**Consultation Response from KC,
Highways Development Management**

2023/92952 2, Hanson Lane, Lockwood, Huddersfield, HD1 3UW

Alterations to convert existing dwelling to 9 bed House of Multiple Occupation and erection of rear dormer

Date Responded: 20-11-2023.

Block Plan
1 : 500

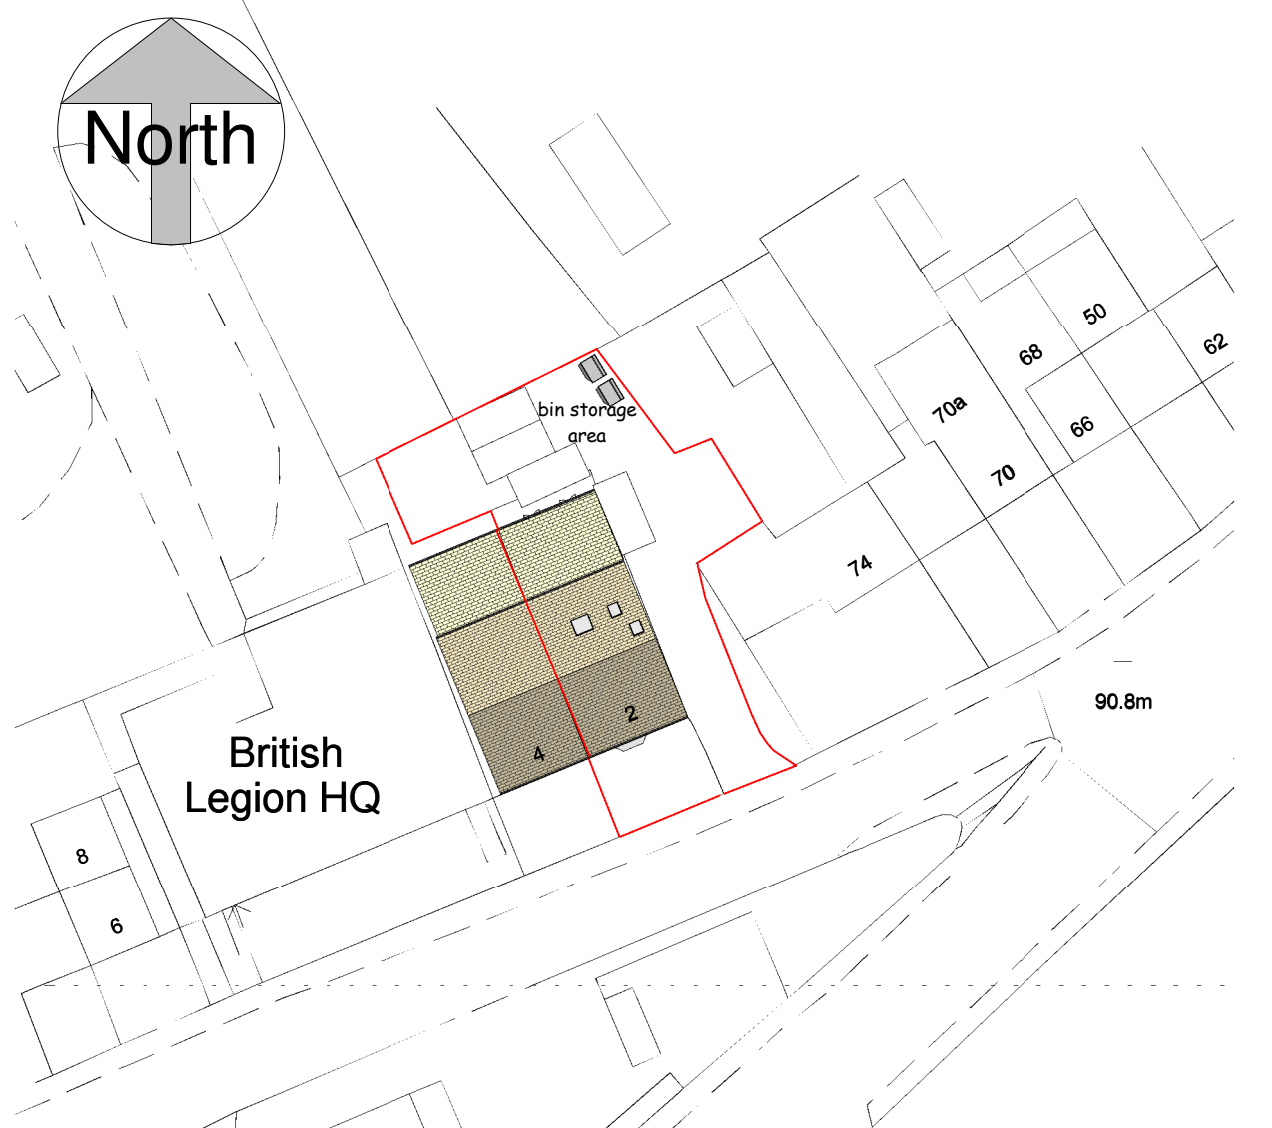
This application provides insufficient information.

The applicants should be asked to provide details of the proposed off-street parking.

The recommended parking standard for a bed-sit or house of multiple occupation is typically one space per two units which results in a need for 4/5 off-street parking spaces.
